Ref: K-28-11 Simcar, 69 Coastal Road East Preston

Re: Planning Application K/28/11, 69 Coastal Road, Kingston.

Rev A: Windows to bedroom/fairly corrected				Nov 2011	
REVISION					
PROJECT					
Proposed development at 'Simcar' Coastal Road, East Preston					
SUBJECT					
Plot 2 - Indicative Plans and Elevation					
SCALE		DATE		DRAWING No	
1:100		Nov 2011			
DRAWN		CHECKED			
11 / 46 / 03				Rev A

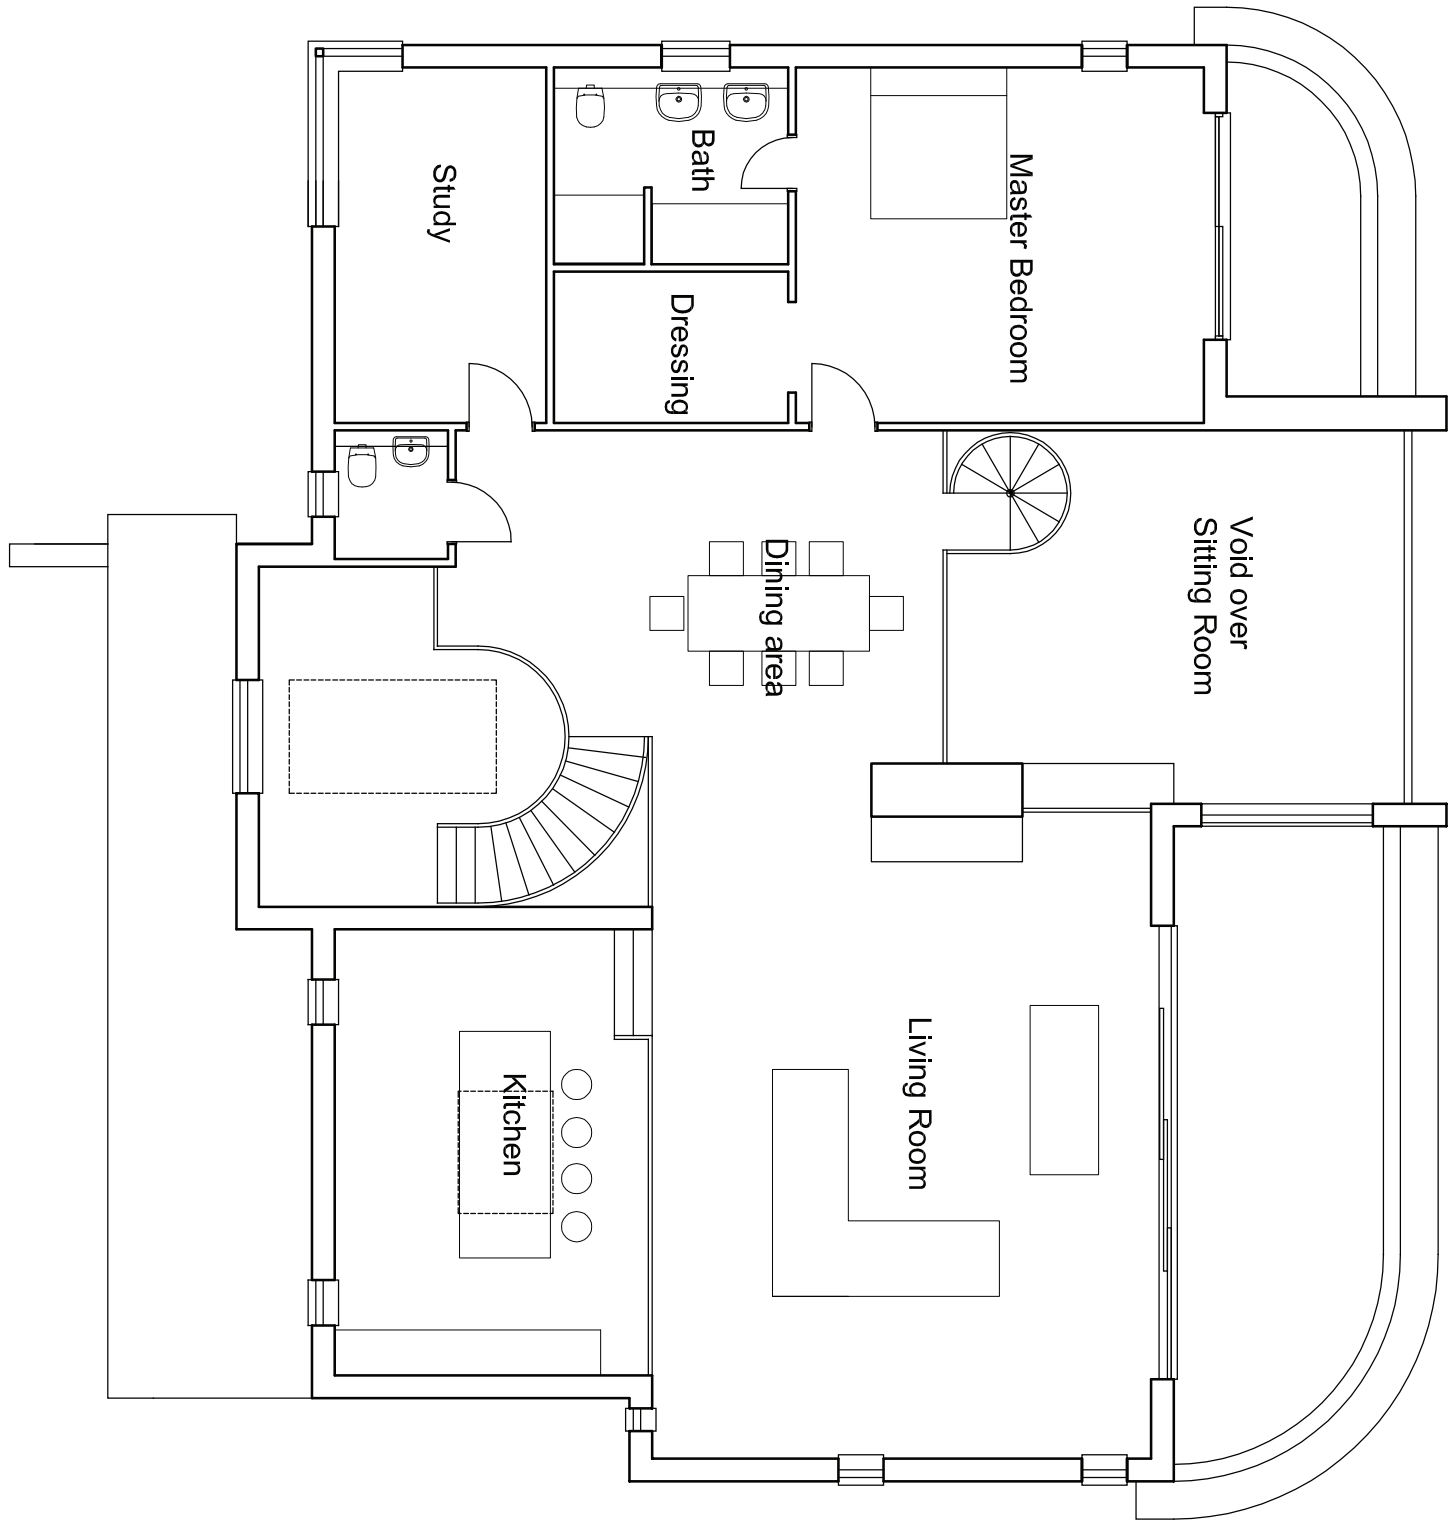
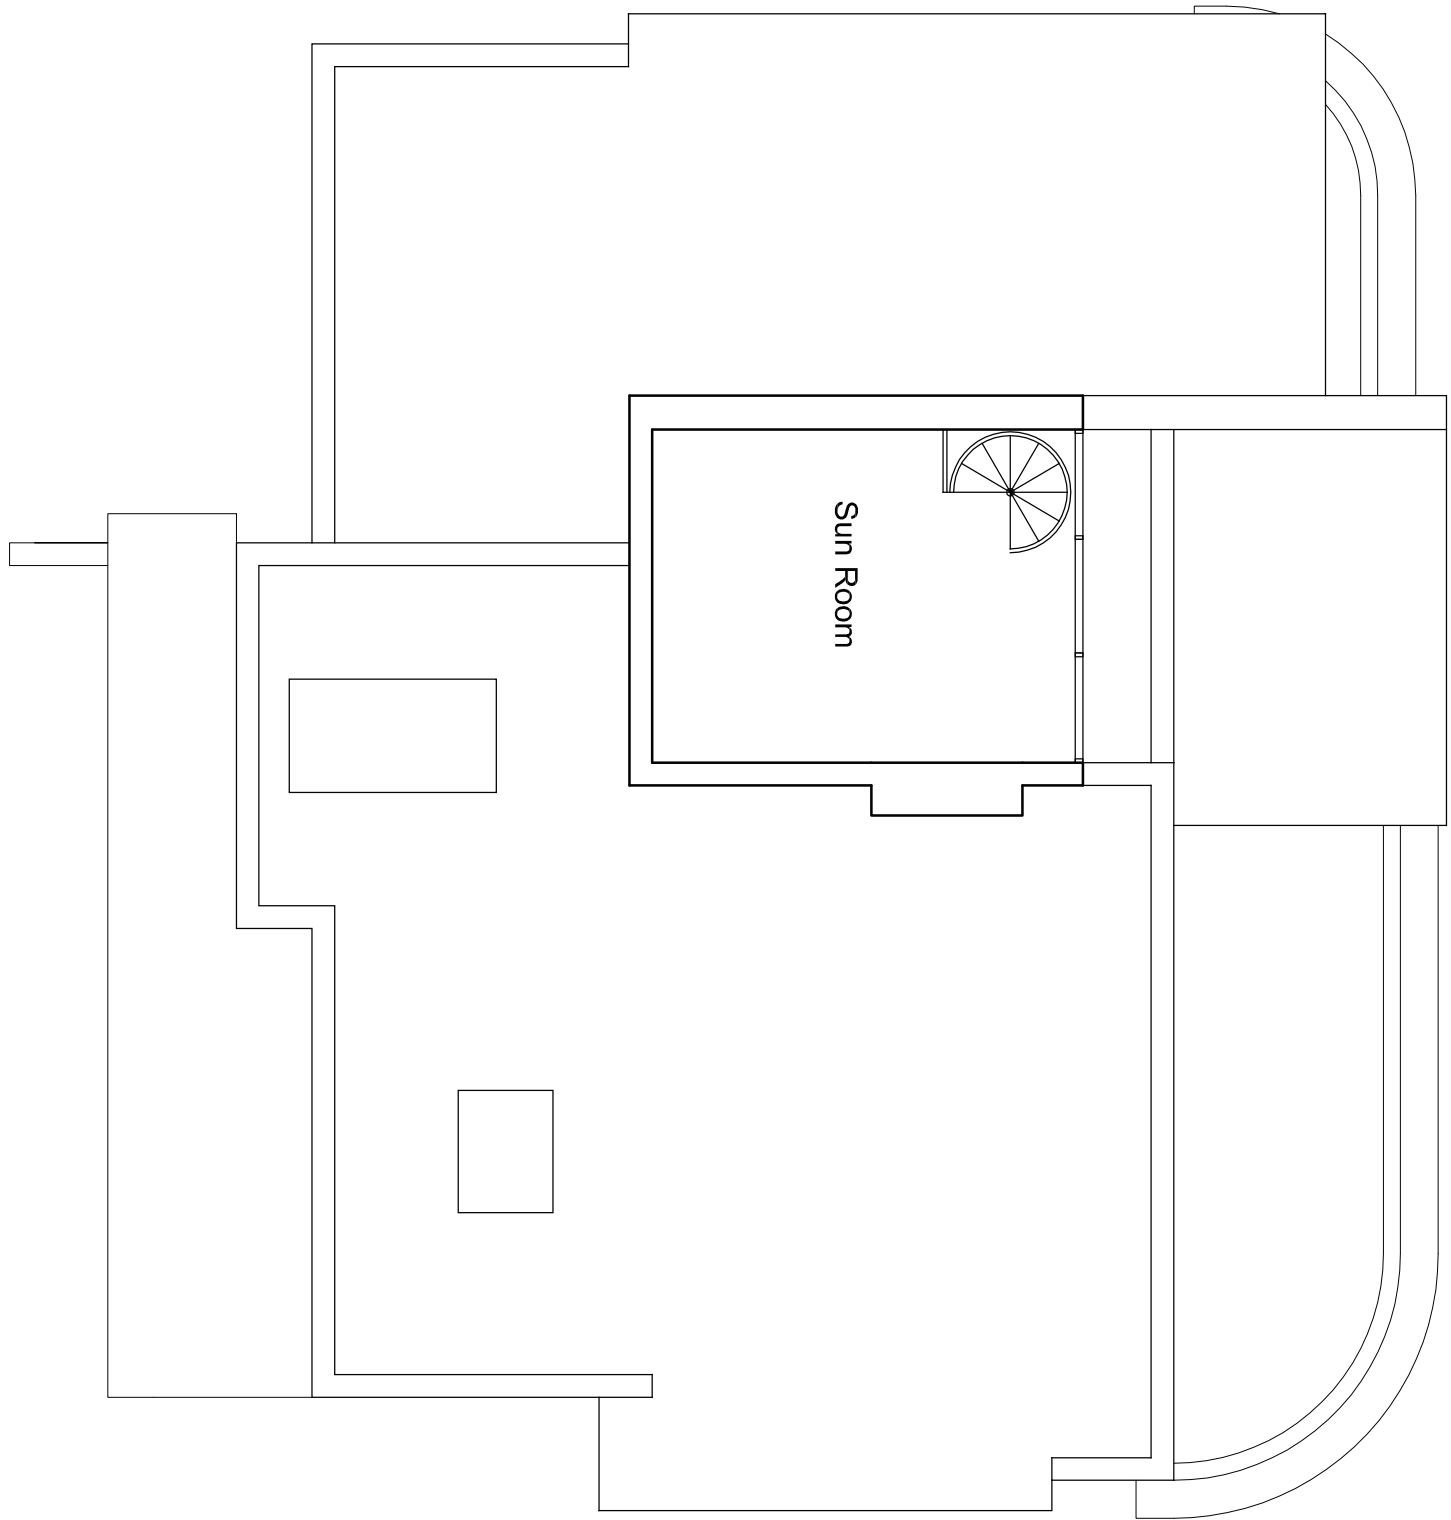
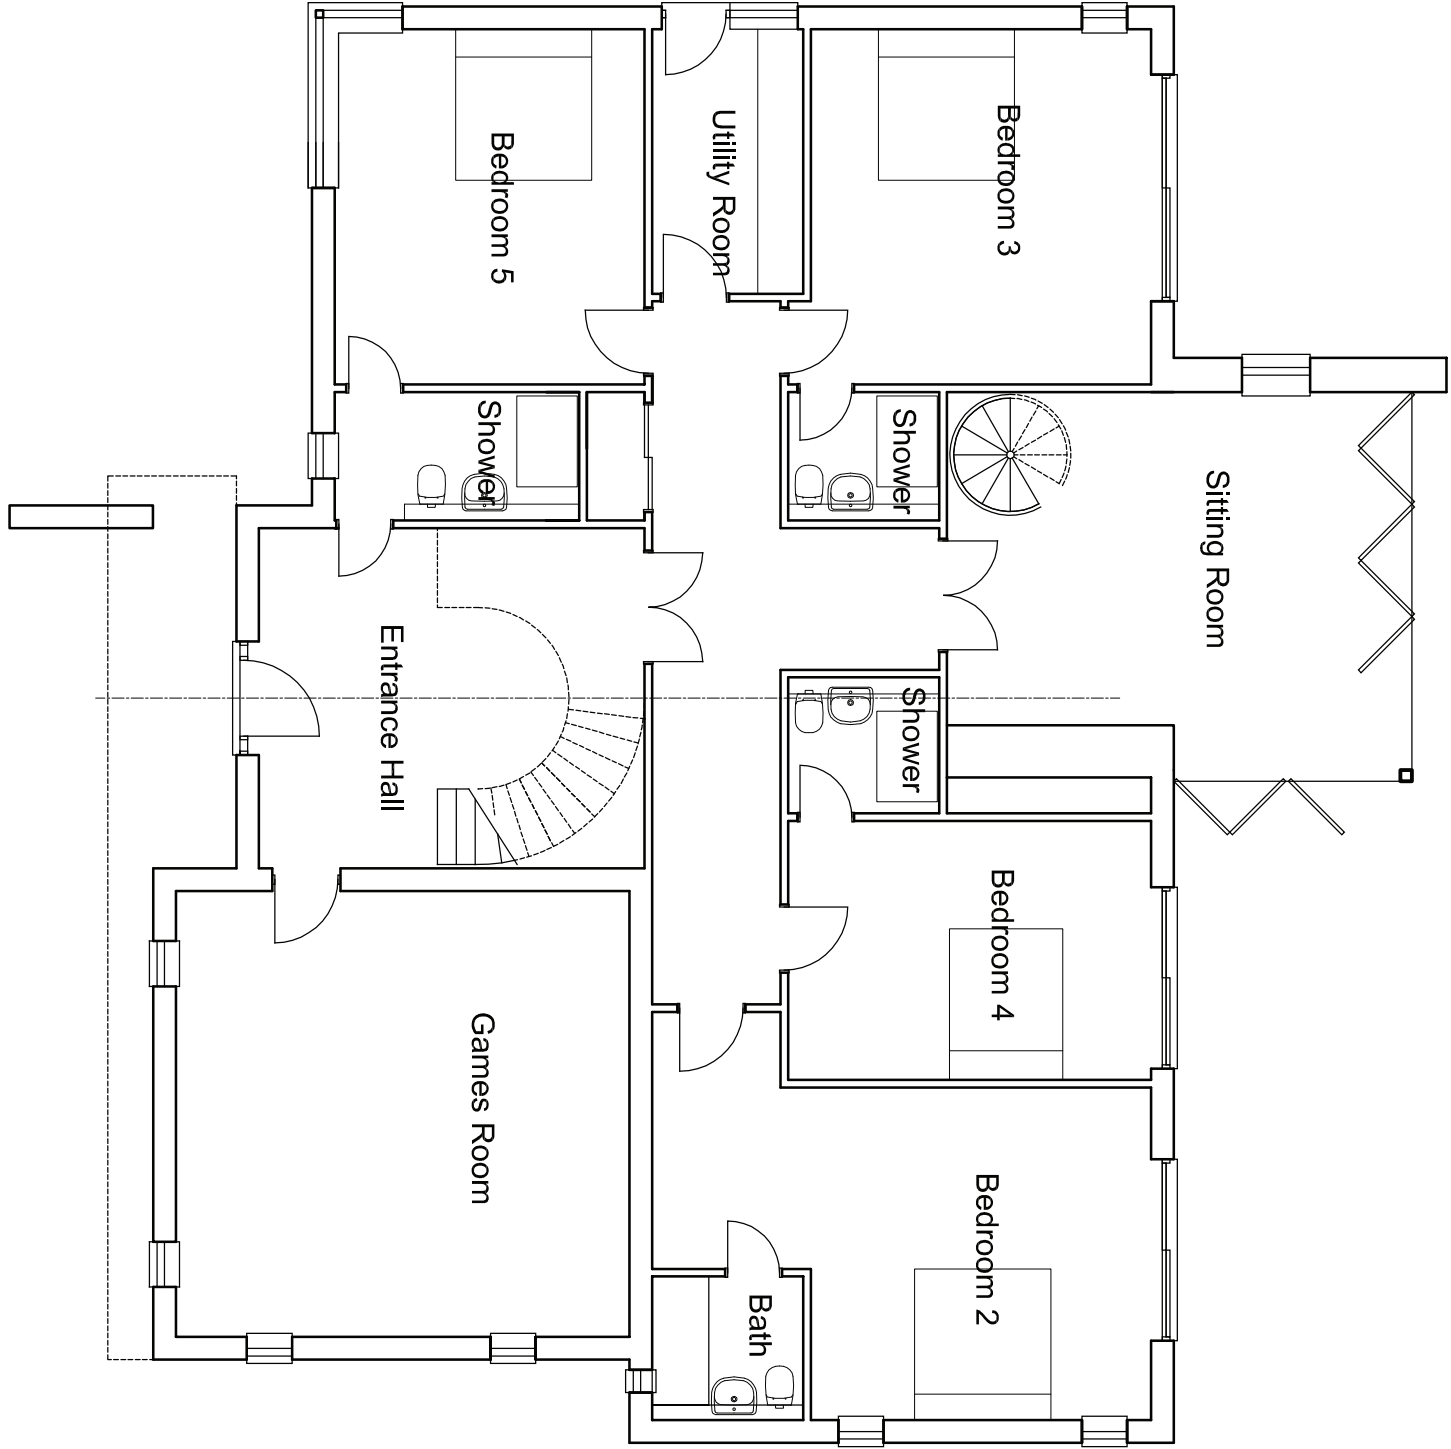
The proposal for, and citing of, a detached double garage for plot 2 is an item of particular concern being immediately adjacent to the boundary to my mother's property and liable to be a visual eyesore and source of noise pollution to the main reception rooms in her property.

- Insist on the deletion of the detached garage to plot 2 with the substitution in line with plot 1 of an integral garage, to replace the intended games room. The resulting reduction to the obvious intrusion to my mother's property will be significant and much appreciated.
- Strongly consider approval to a maximum of four bedrooms for each plot in an attempt to place a perfectly reasonable restriction, given the hammerhead access location, on the likely increase in vehicular traffic and associated off-street parking.

I am the owner of Genesis, Golden Acre, East Preston. On looking at the plans of the above application I have concerns that the new dwelling, Plot 2, is very near to my Eastern Boundary. Also, I am concerned regarding the height as detailed:

- 1) My main concern is that the main property is so close to my property – approx. 3m, where the existing house to be demolished is approx. 10m from the boundary.
The garage at the rear is completely unacceptable being very tight to the boundary tree line. It would be impossible to build so close to these trees. Most of the trees are 15 to 18 inches thick; they would have to be removed.

- 2) My other concern is the sun terrace on the roof of the house. The sun terrace makes this house into a three storey property. Anyone on the sun terrace would be able to look into all the other gardens around. It would also encourage the future owners to use this area for entertainment. I can foresee a problem with noise from this roof terrace that would be very unsettling, not only for myself and family but also to other properties in the area. Surely, with the size of the south facing plot with sea views why is a third floor sun terrace needed?
